PLAN REVIEW SHEET

Petition #: RZP 2020-140

Request: UR-2 CD

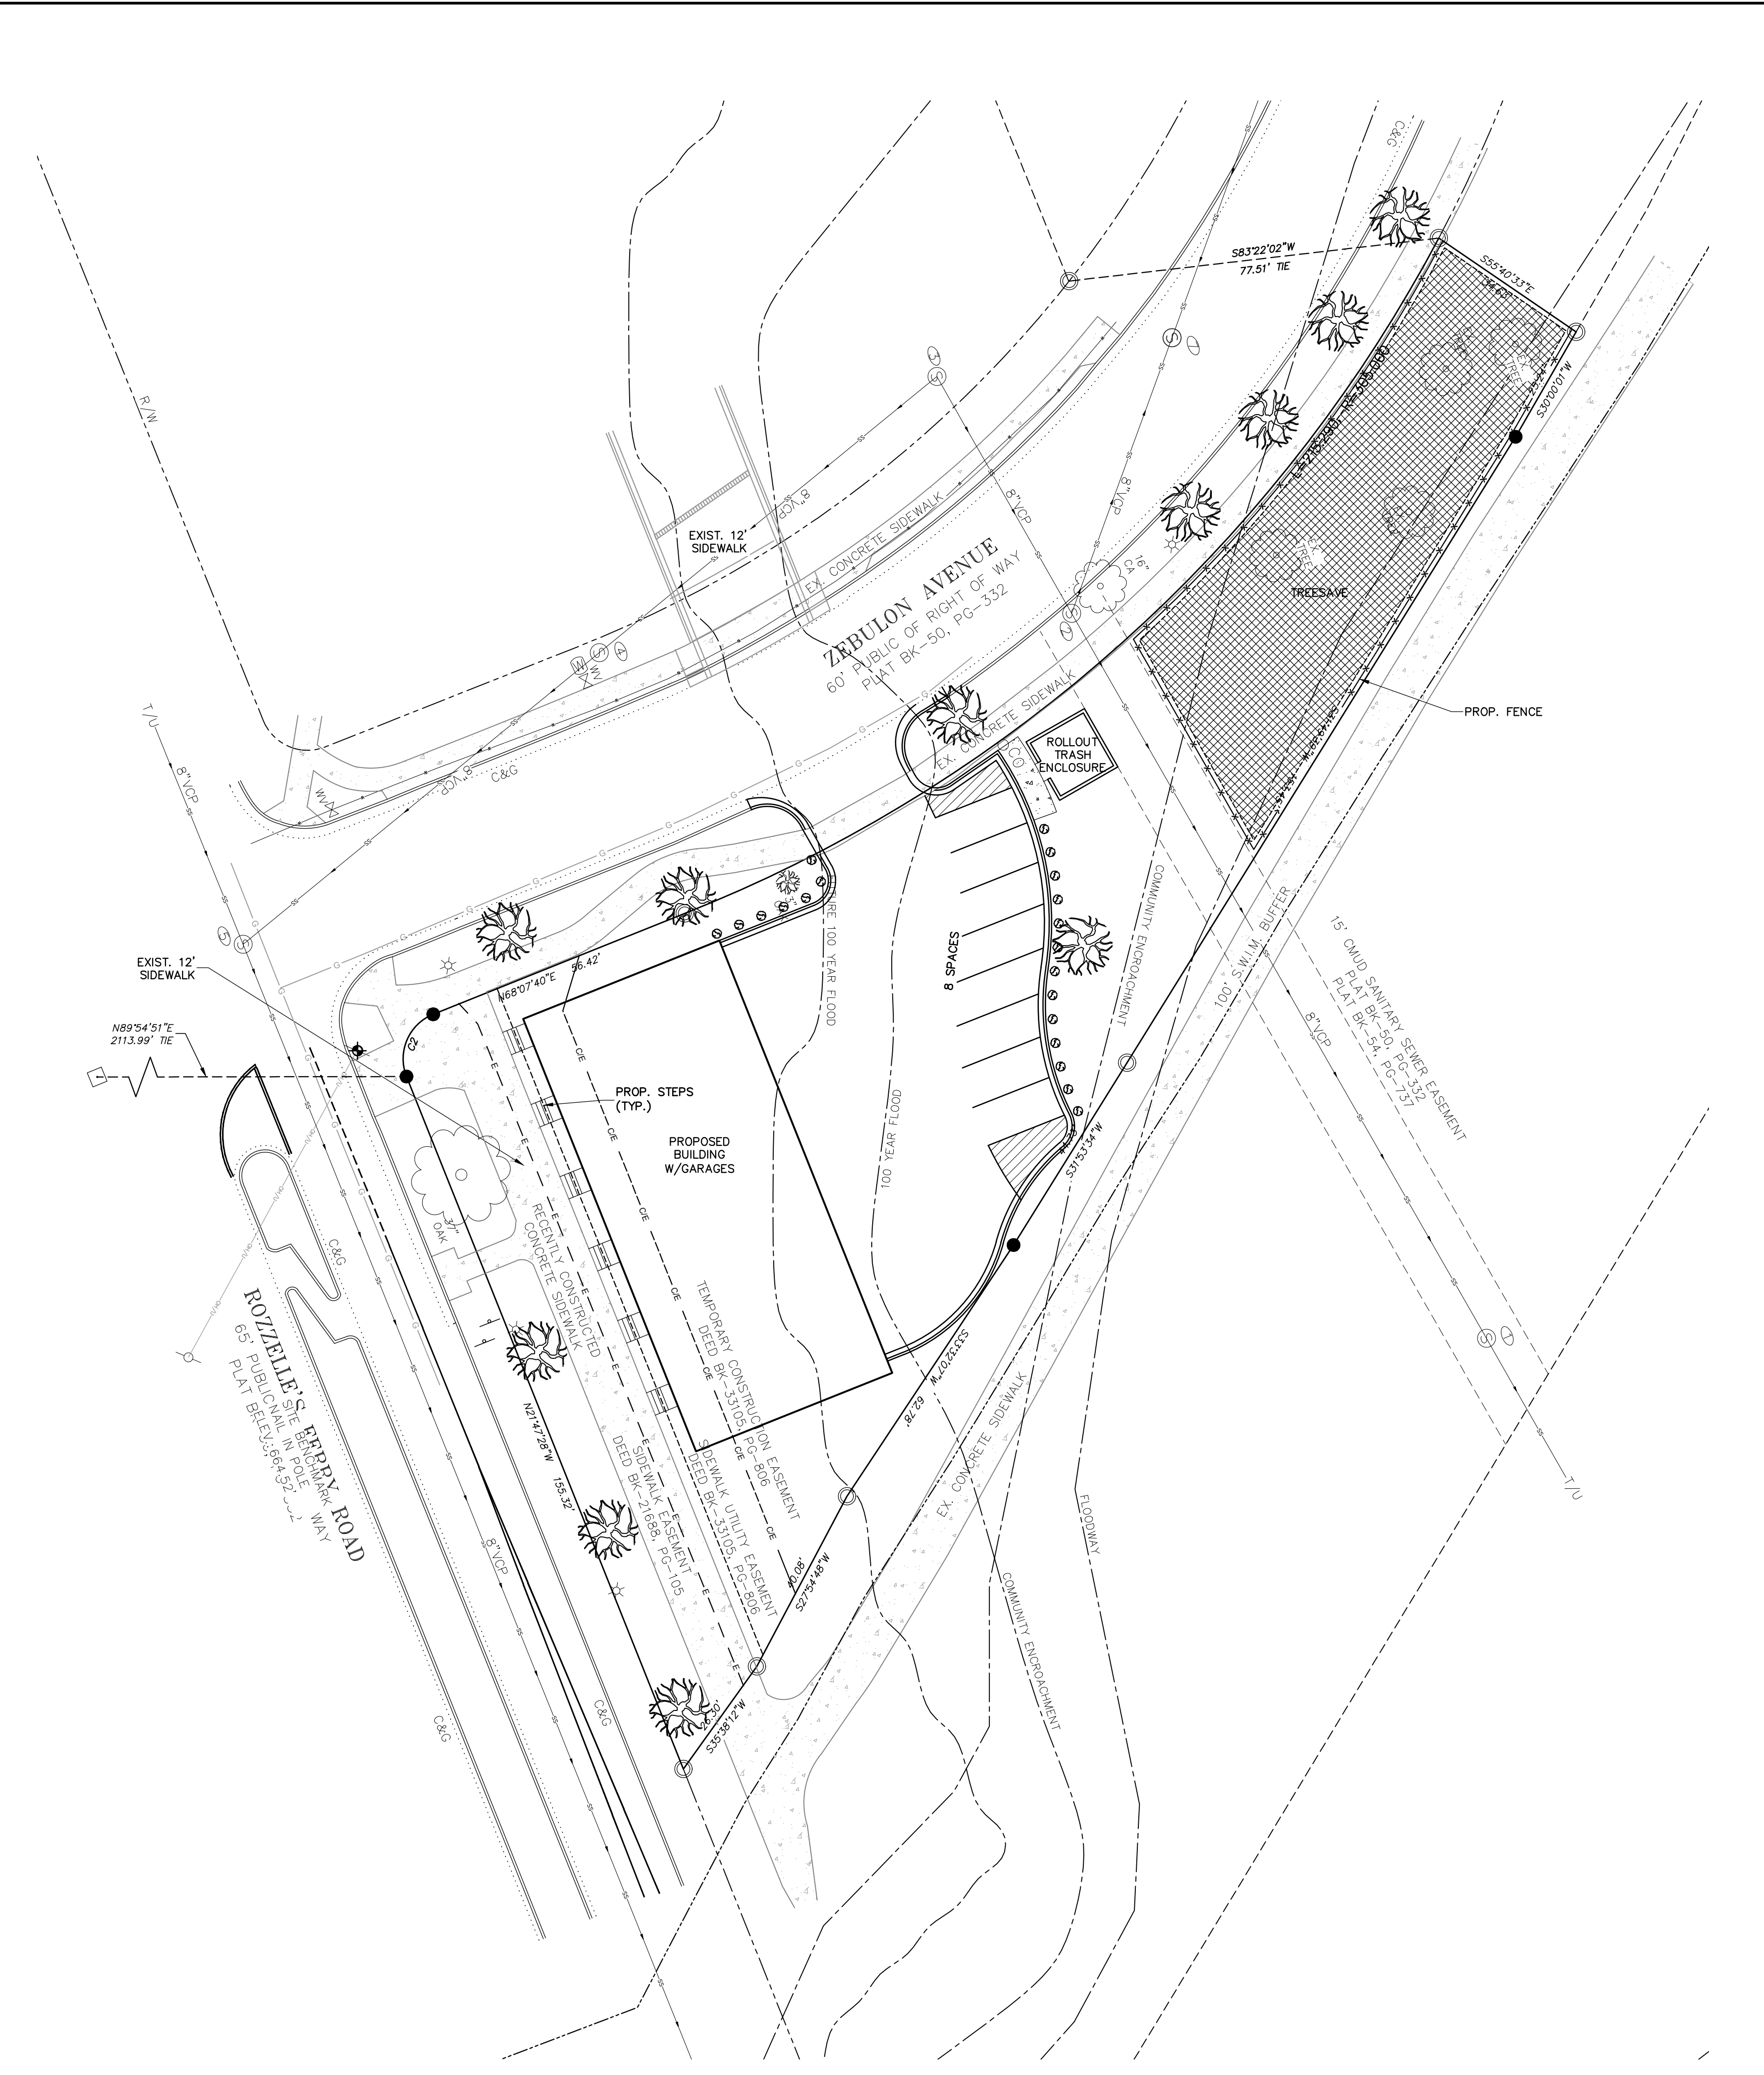
The site is located along CATS local bus route #1 along Rozzelles Ferry Road. CATS requests the petitioner to construct an ADA compliant bus waiting pad per Land Development Standard 60.01B near the location of the existing stop (ID #24860). The final location of the pad will be coordinated with the developer and CDOT through the permitting process.
